## Appeal Decision

**Appeal Ref: APP/R5510/D/25/3367843**

**61 Farmlands, Eastcote, Hillingdon HA5 2LN**

- The appeal is made under section 78 of the Town and Country Planning Act 1990 (as amended) against a refusal to grant planning permission.
- The appeal is made by Mr. and Mrs. Ravindran against the decision of the Council of the London Borough of Hillingdon.
- The application Ref is 48640/APP/2025/785.
- The development proposed is described as the “creation of crossover to front garden”.

Proposed Site Plan - 1:200

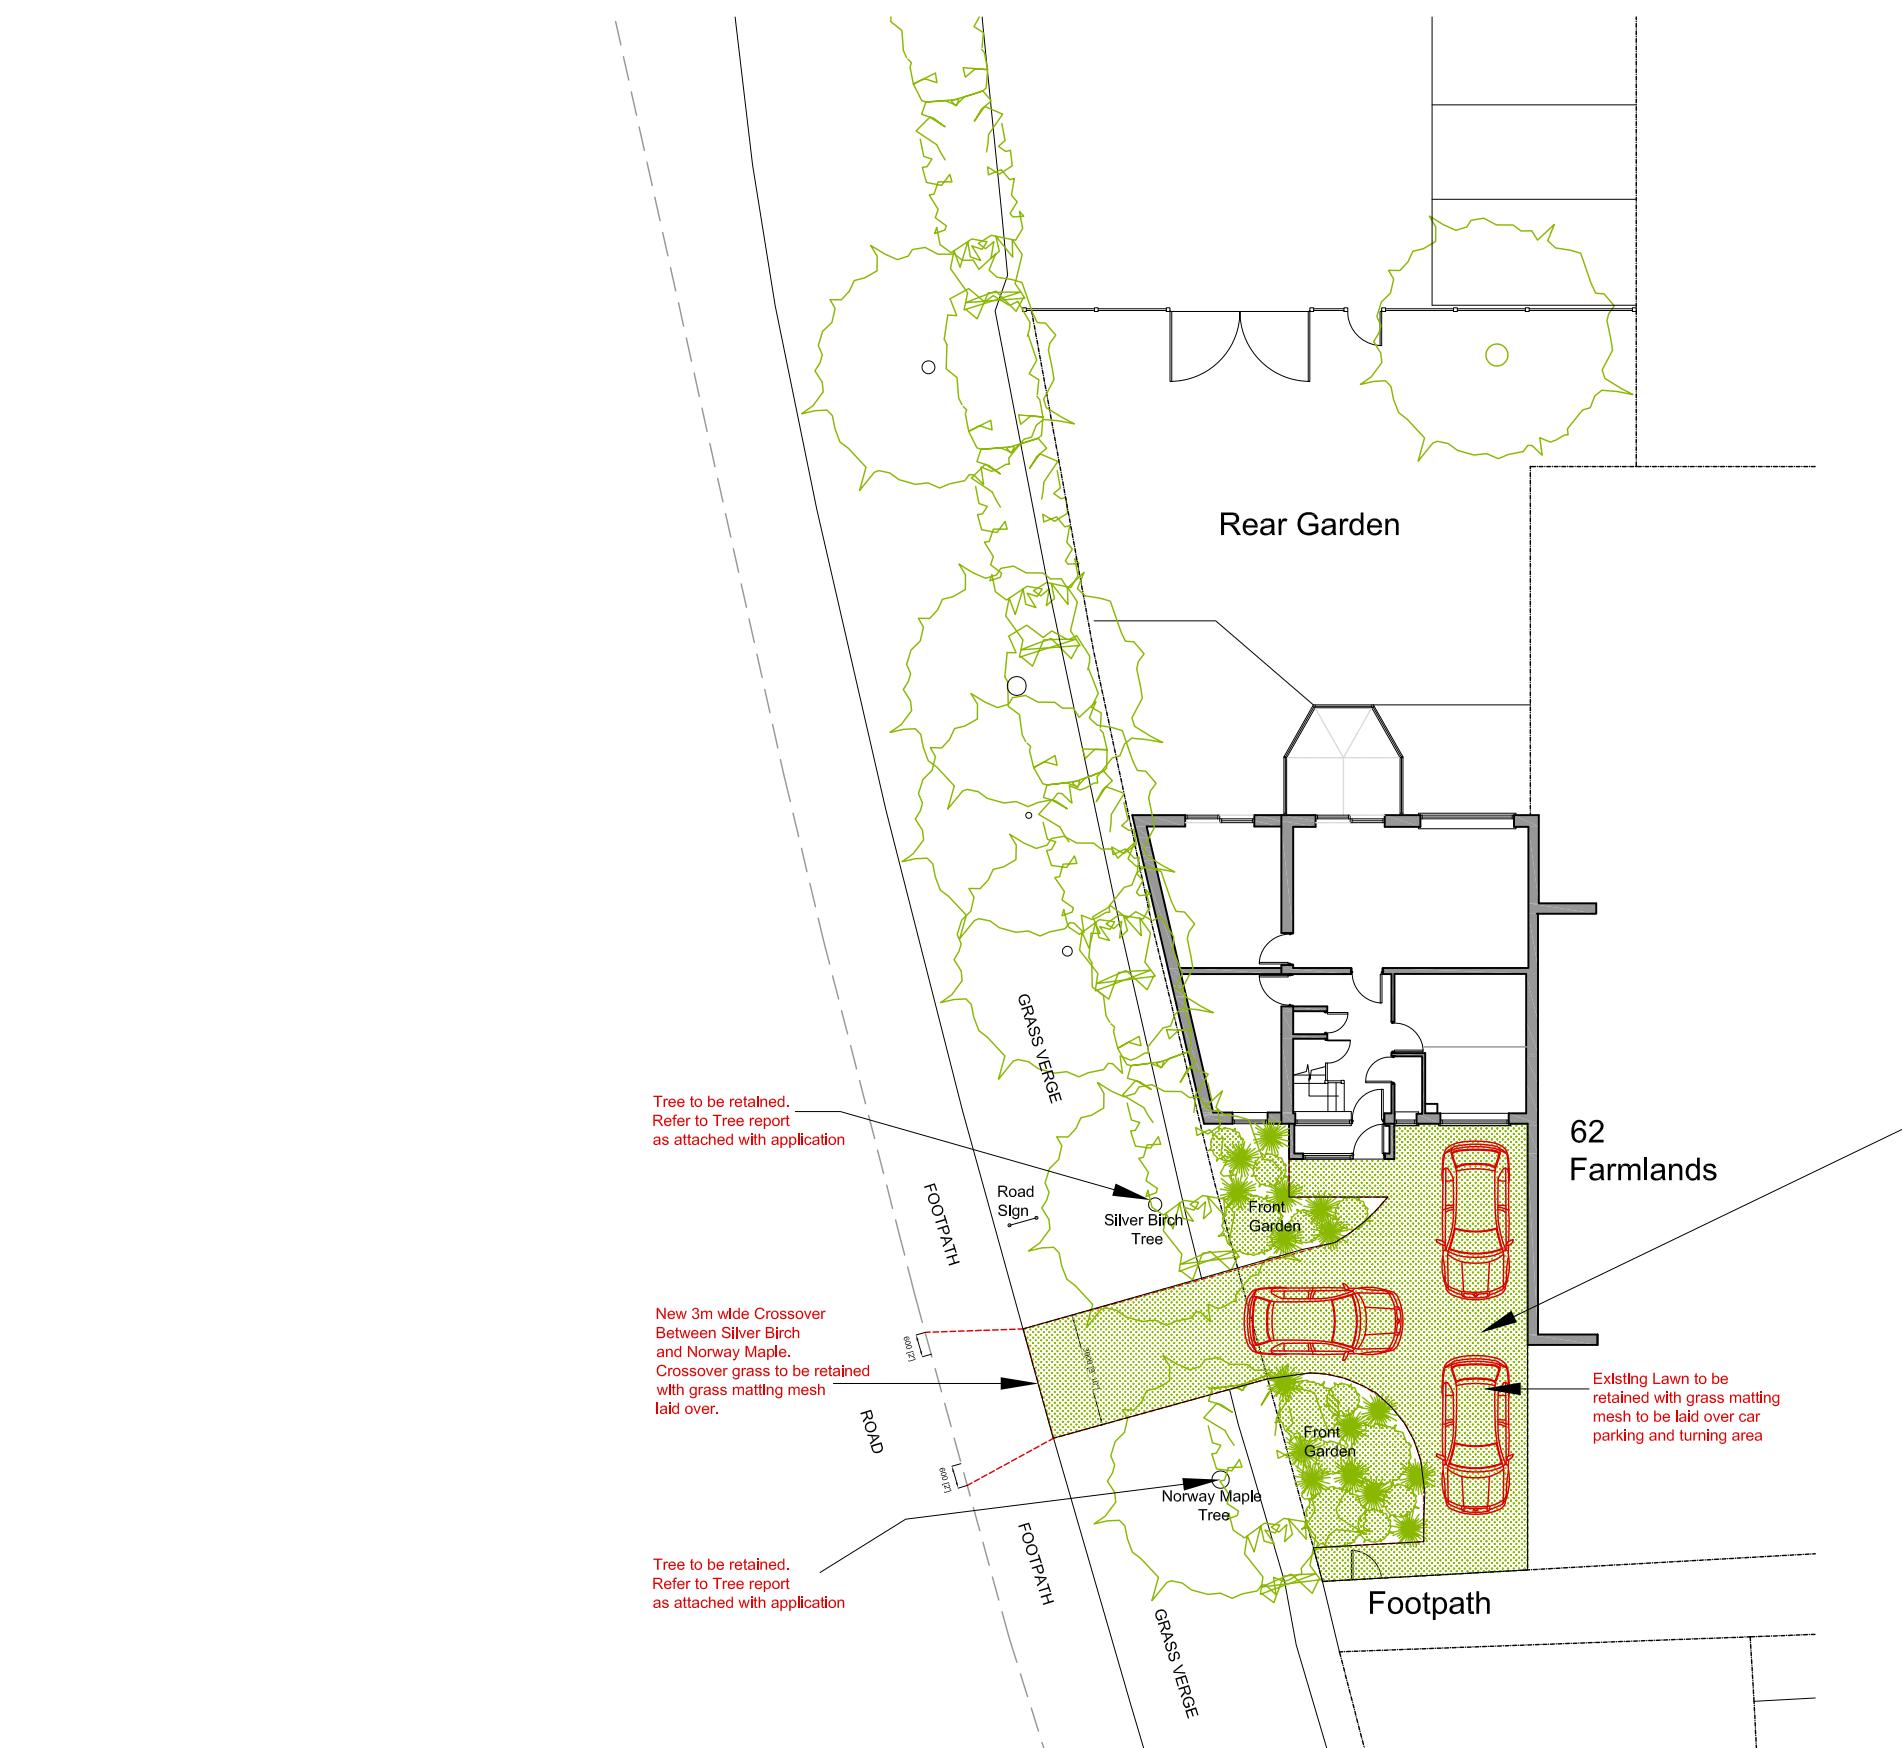
5. The turf mesh material for the vehicular crossover and the parking and turning area is intended to retain a green and grassed appearance. Despite this, the proposed surfacing material would introduce an artificial texture which would be publicly visible from the grass verge. This would appear as a discordant feature which would disrupt the continuity of the established soft landscaping along Joel Street.

treatment is proposed to the Root Protection Areas (RPAs). Whilst the construction process itself may not pose immediate harm; I cannot be satisfied that the frequent passage of vehicles over the RPAs would not lead to soil compaction over time. Such compaction could disrupt and damage the root systems and ultimately compromise the health of both trees in the future. As they form an important part of the established rhythm and continuity of the tree line along Joel Street, their loss would be unacceptably detrimental to the character and appearance of the area.

8. The plans indicate that the proposed turning area would allow for a single vehicle to manoeuvre and exit the site in forward gear. However, this would rely on only one vehicle being owned and parked at the property all the time. There is potential for additional vehicles to be owned and parked on site in the future. In such circumstances, the available turning space would be insufficient to enable forward egress. This would result in vehicles having to either reverse in or out of the access. For the former, a car would have to stop in a live carriageway and impede the free flow of traffic. For the latter, such a manoeuvre would bring with it the added difficulty of restricted visibility for the exiting driver, increasing the risk of conflict with pedestrians, cyclists or other vehicles.
